Please ask for: Sian Eggington
Email: sian.eggington@terraquest.co.uk
Telephone: 0121 2341390
Our Ref: BN/54/20/HH
Your Ref:
Date: 2nd June 2020

Application for Planning Permission for Works or Extension to a Dwelling

Development: Proposed single storey extension to courtyard area and changes to fenestration. (This application may affect the character and appearance of the Church Lane Conservation Area) (The application may affect the setting of a listed building)

Location: Minstrels Barn Church Lane Barnham PO22 0BX

DRAWING NUMBER
13062/101

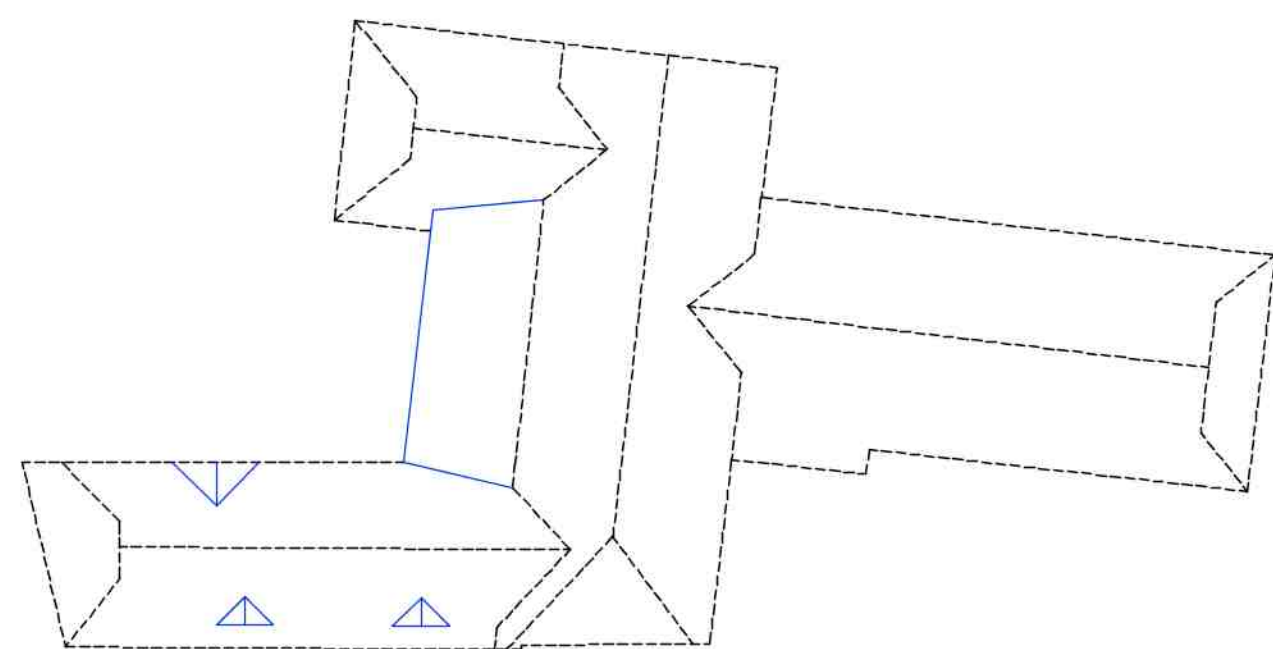
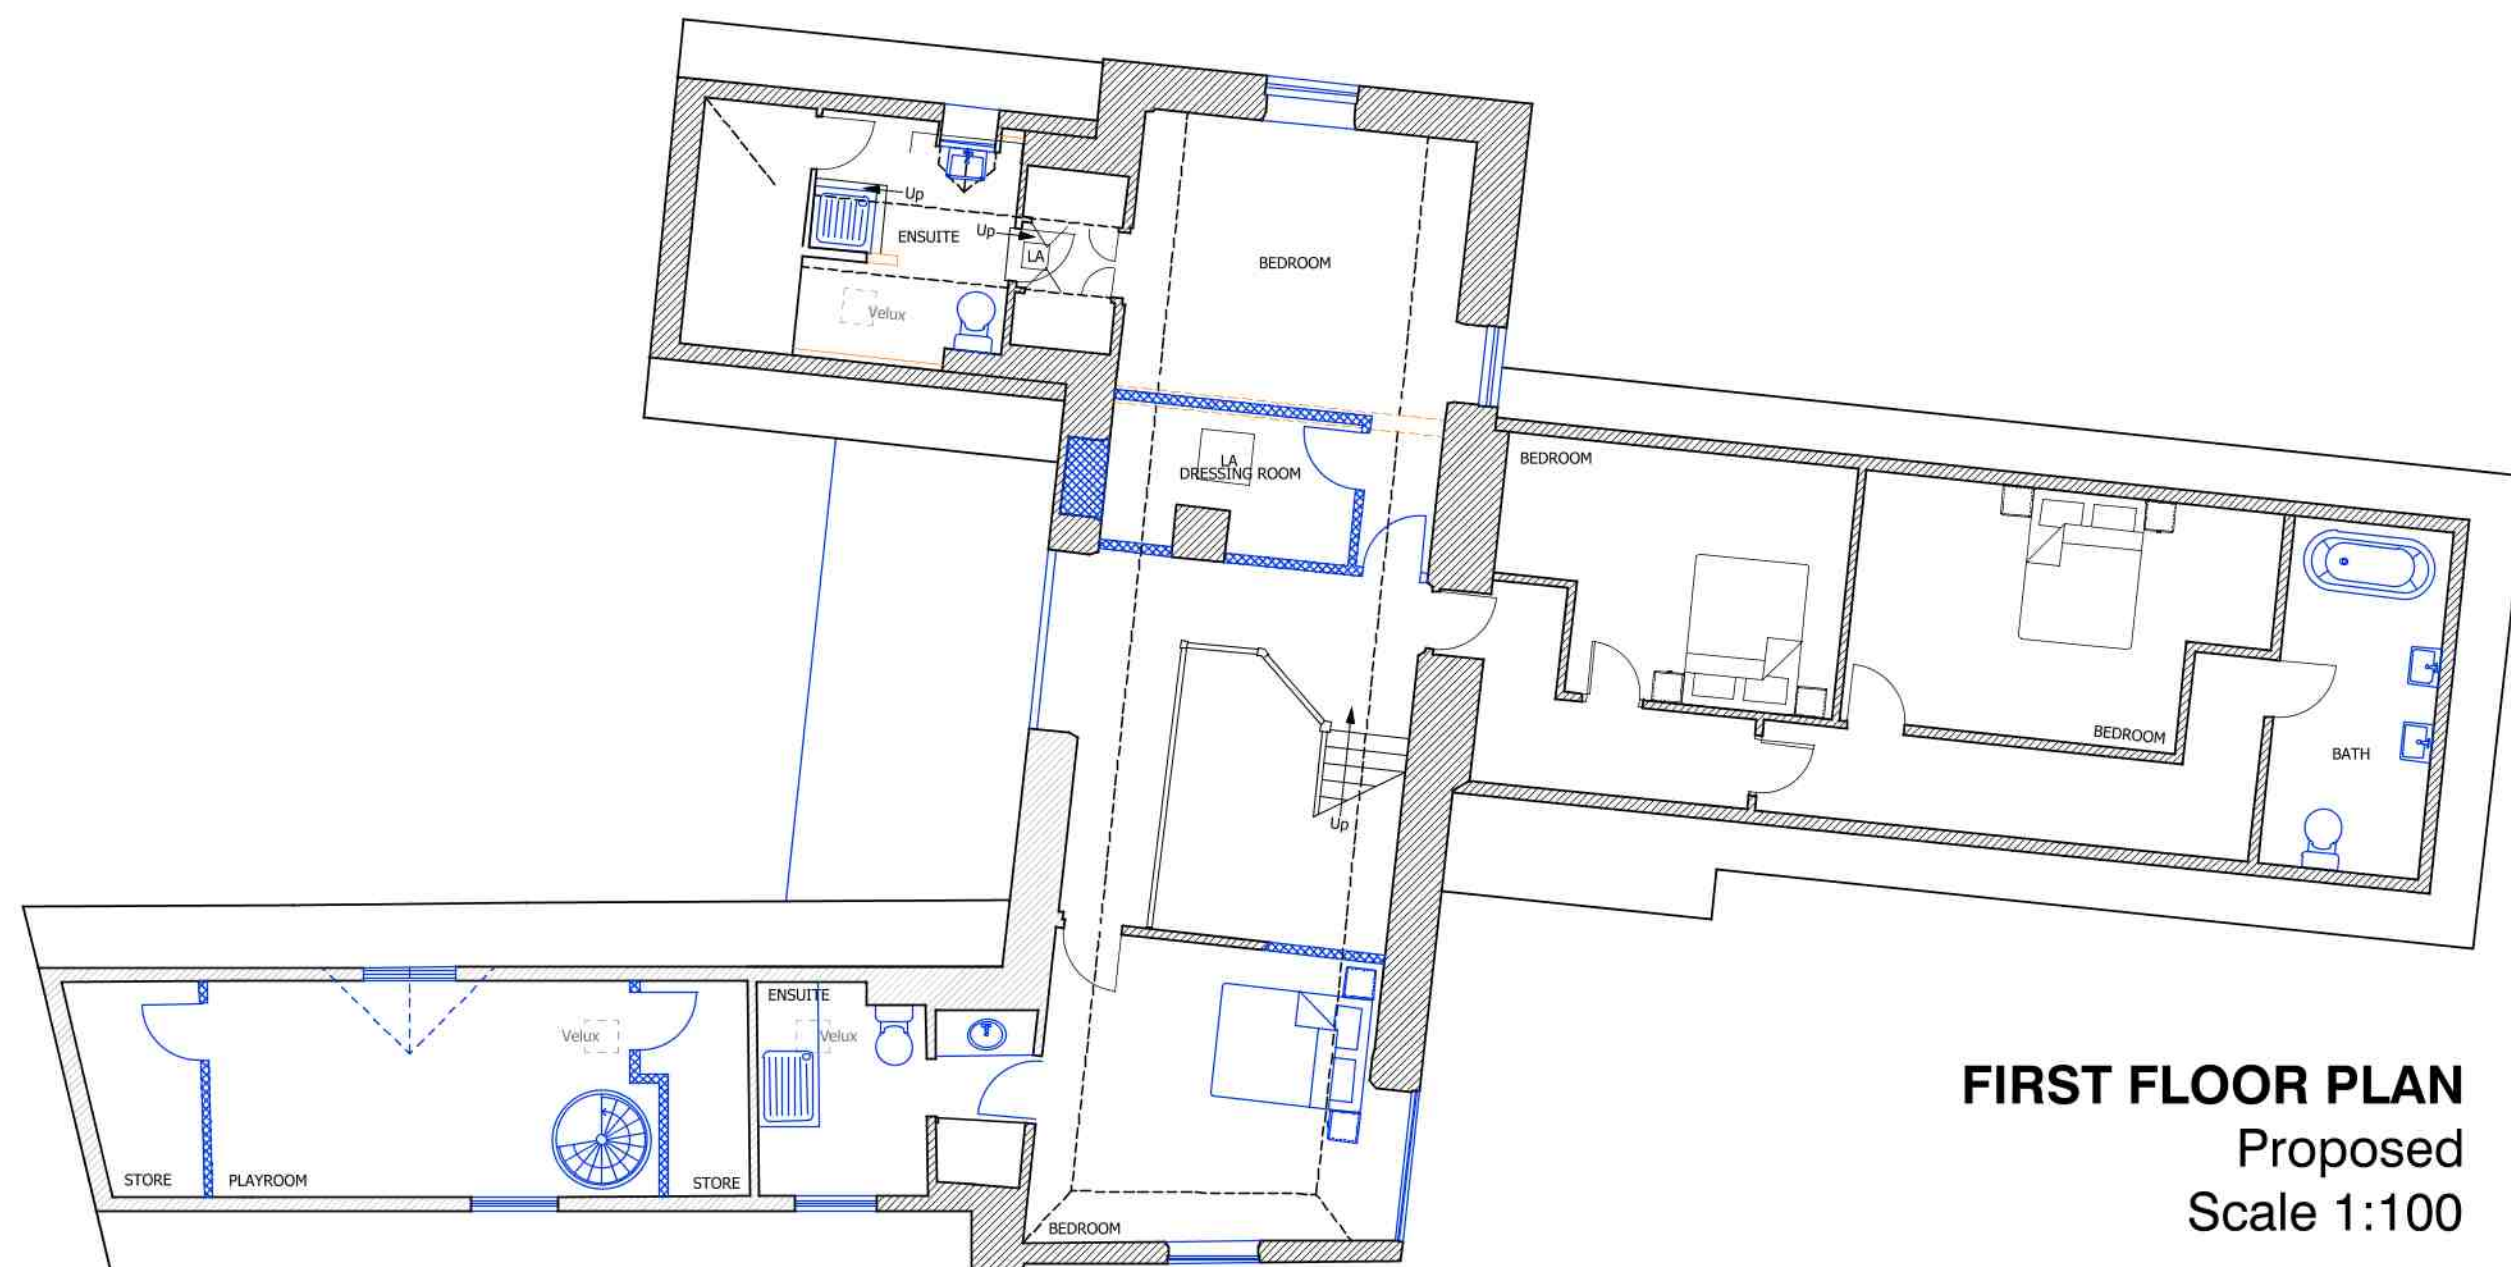
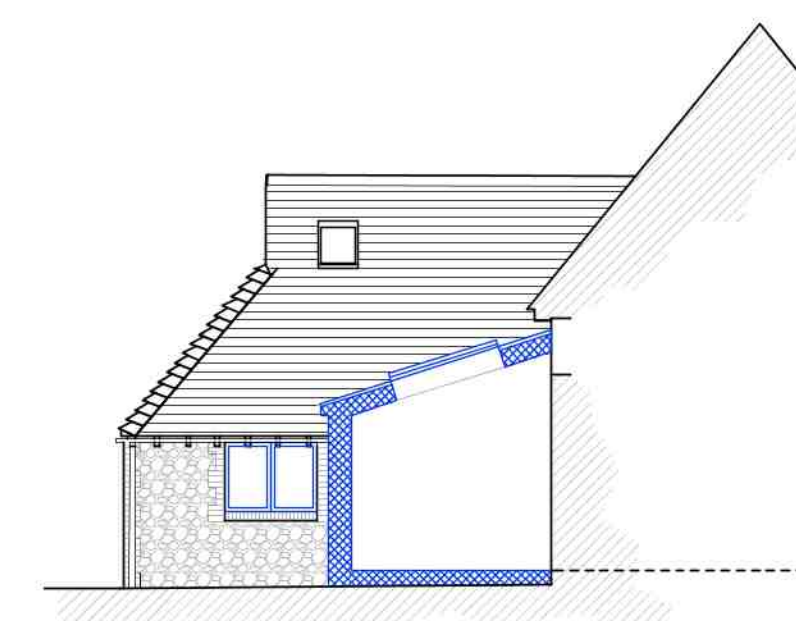
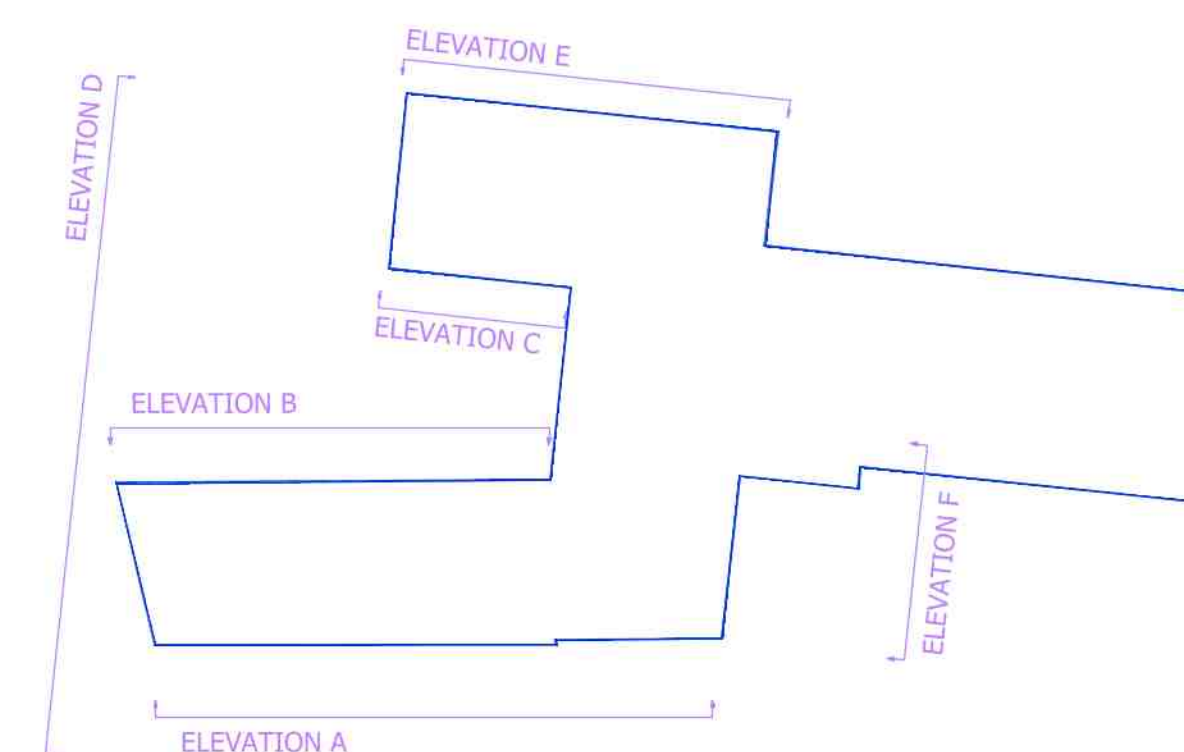
Confirmation Required: Please confirm if you are converting part of the first floor. If not please add room labels to the first floor to show no conversion will be taking place.
